SF2020/069117; WST20/00116/02

SSD-10452: Blue Springs Road, Gulgong; Stubbo Solar Farm

Thank you for referral of SSD-10452 to Transport for NSW (TfNSW) via the NSW Planning Portal. It is understood the application is for construction, operation and decommissioning of a 400 megawatt solar farm. Vehicular access to the development is proposed from Blue Springs Road via its intersection with and Cope Road (MR598).

Figure A 28: Basic right (BAR) turn treatment on a two-lane rural road

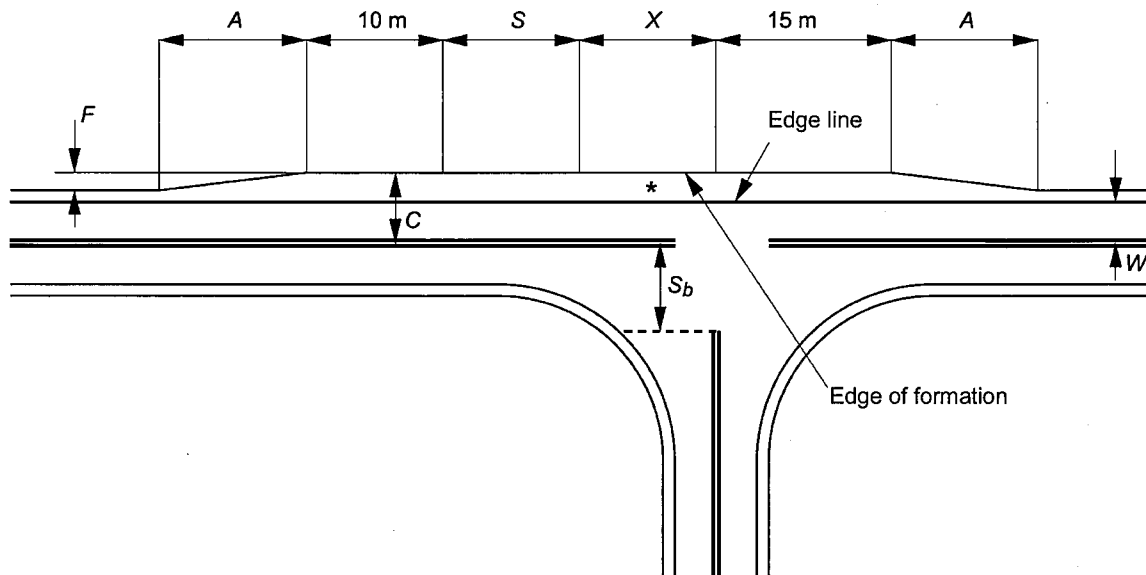
- A Basic Right (BAR) turn treatment in accordance with Part 4 A28 (copy enclosed). The BAR treatment is to be sealed, designed and constructed for a 100km/h speed environment, able to accommodate the largest vehicle using the intersection, match existing road levels and not interfere with existing road drainage.

Figure 8.2: Rural basic left-turn treatment (BAL)

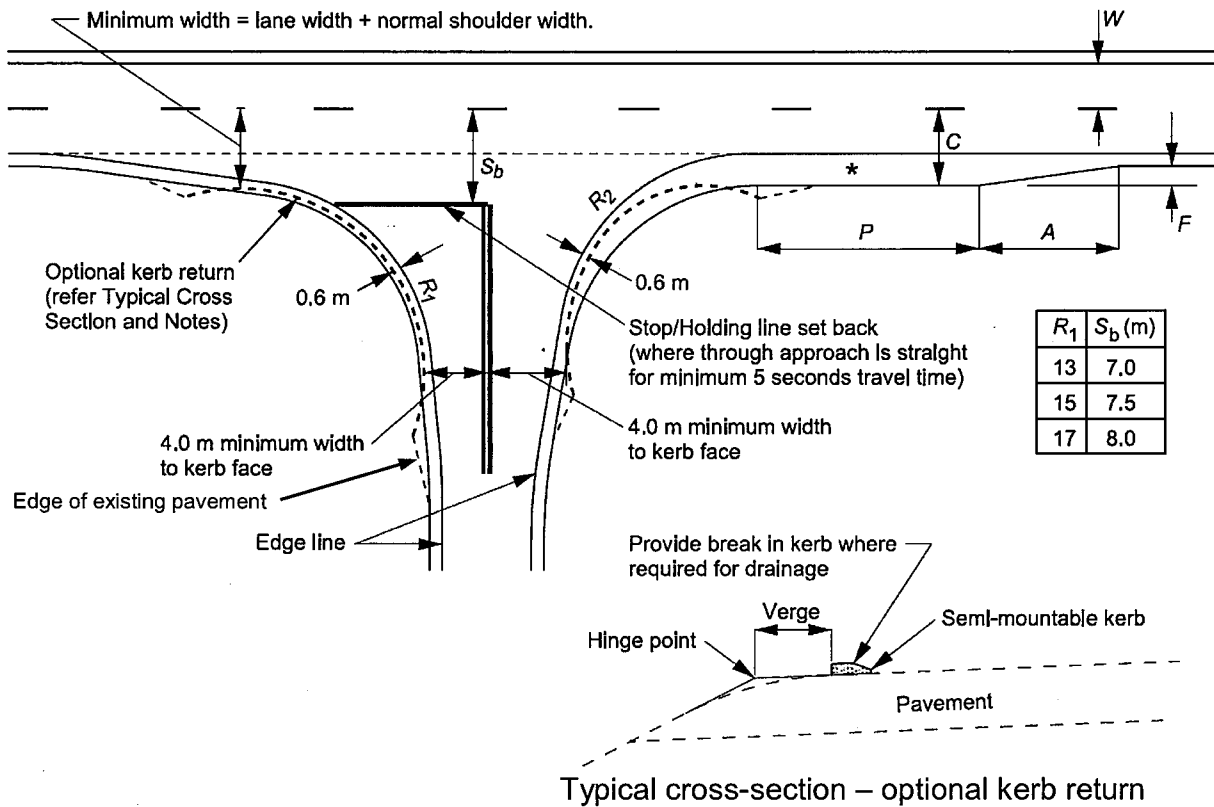
- A Basic Left (BAL) turn treatment as shown in Figure 8.2 Part 4A (copy enclosed). The BAL facility is to be sealed, designed and constructed for a 100km/h speed environment, able to accommodate the largest vehicle using the intersection, match existing road levels and not interfere with existing road drainage.
